FORMAL OBJECTION TO PLANNING APPLICATION 2026/62/90310/E

I write to object in full to planning application **2026/62/90310/E** for the erection of 37 dwellings with associated access, parking, landscaping and creation of a multifunctional area of public open space on land off Sunny View, White Lee, Batley.

Proposed Site Layout

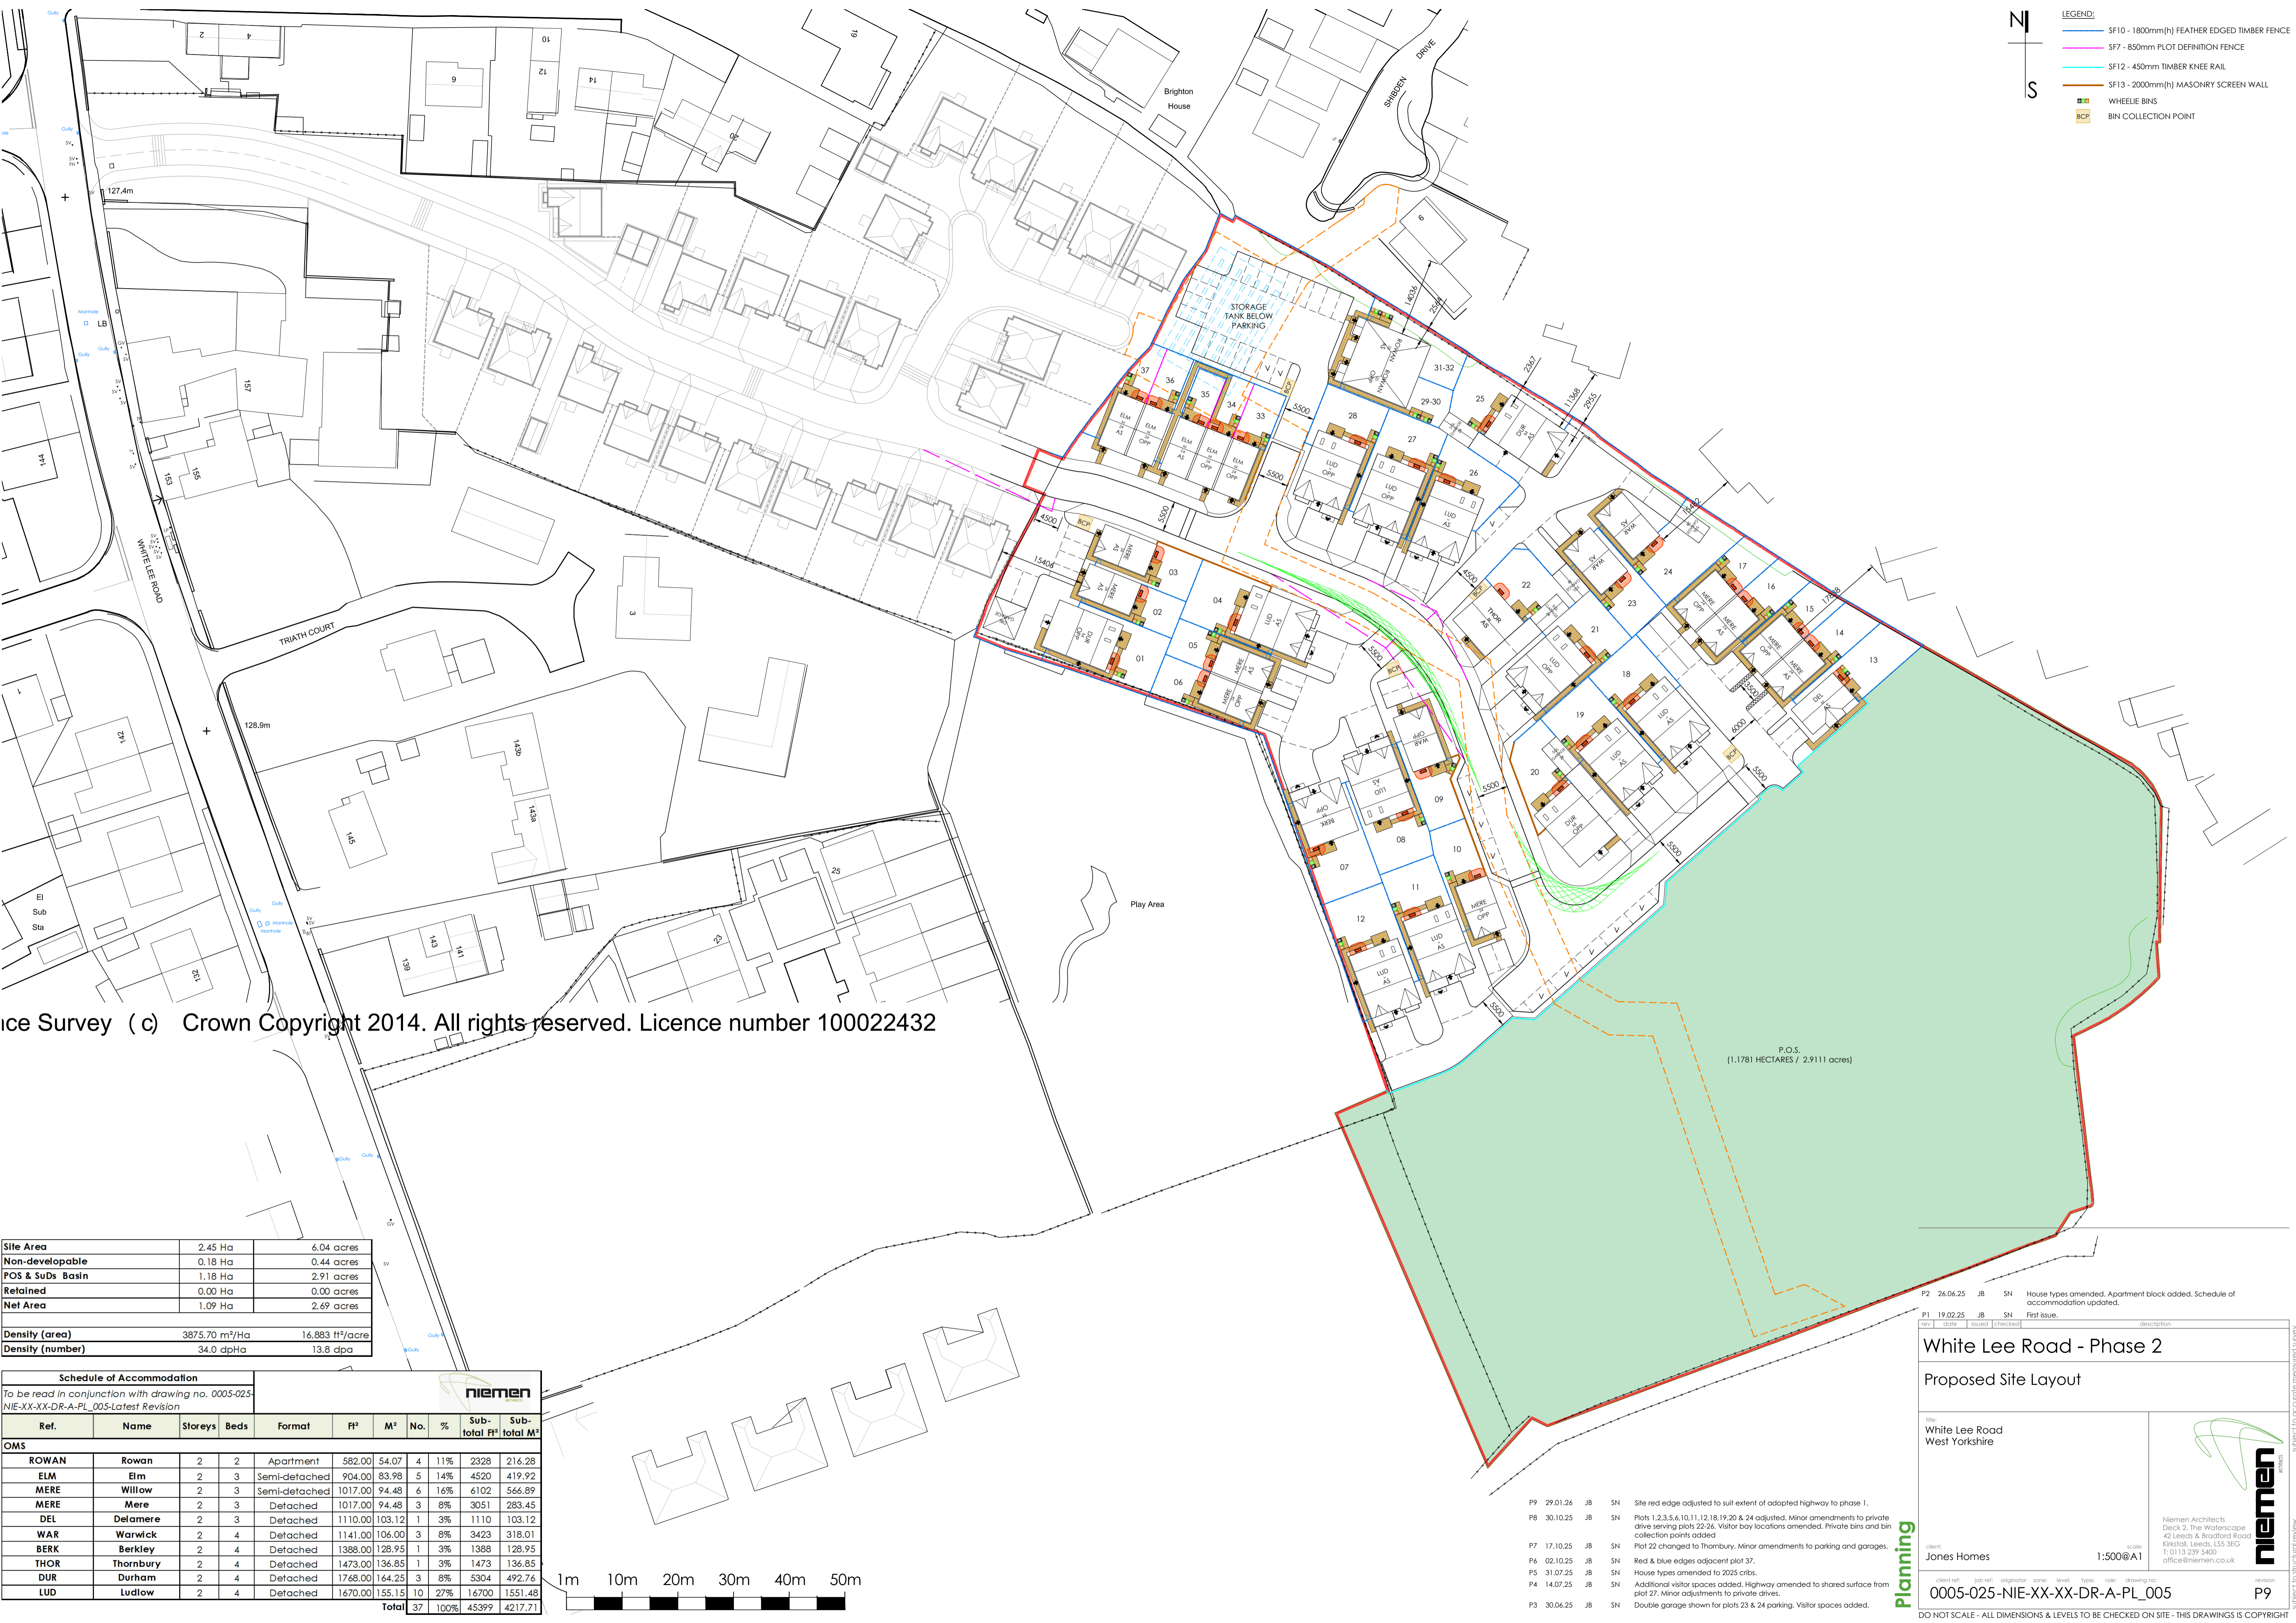
The submitted layout identifies a **“STORAGE TANK BELOW PARKING.”** That confirms the scheme depends on engineered drainage infrastructure embedded within the built development. That raises obvious issues of:

- long-term inspection and maintenance;
- access for repair;
- ownership and responsibility;
- failure scenarios;
- exceedance routing if the system does not perform as intended.

LP28 specifically requires long-term management and maintenance of drainage infrastructure. At present, the application does not demonstrate this to the necessary standard.
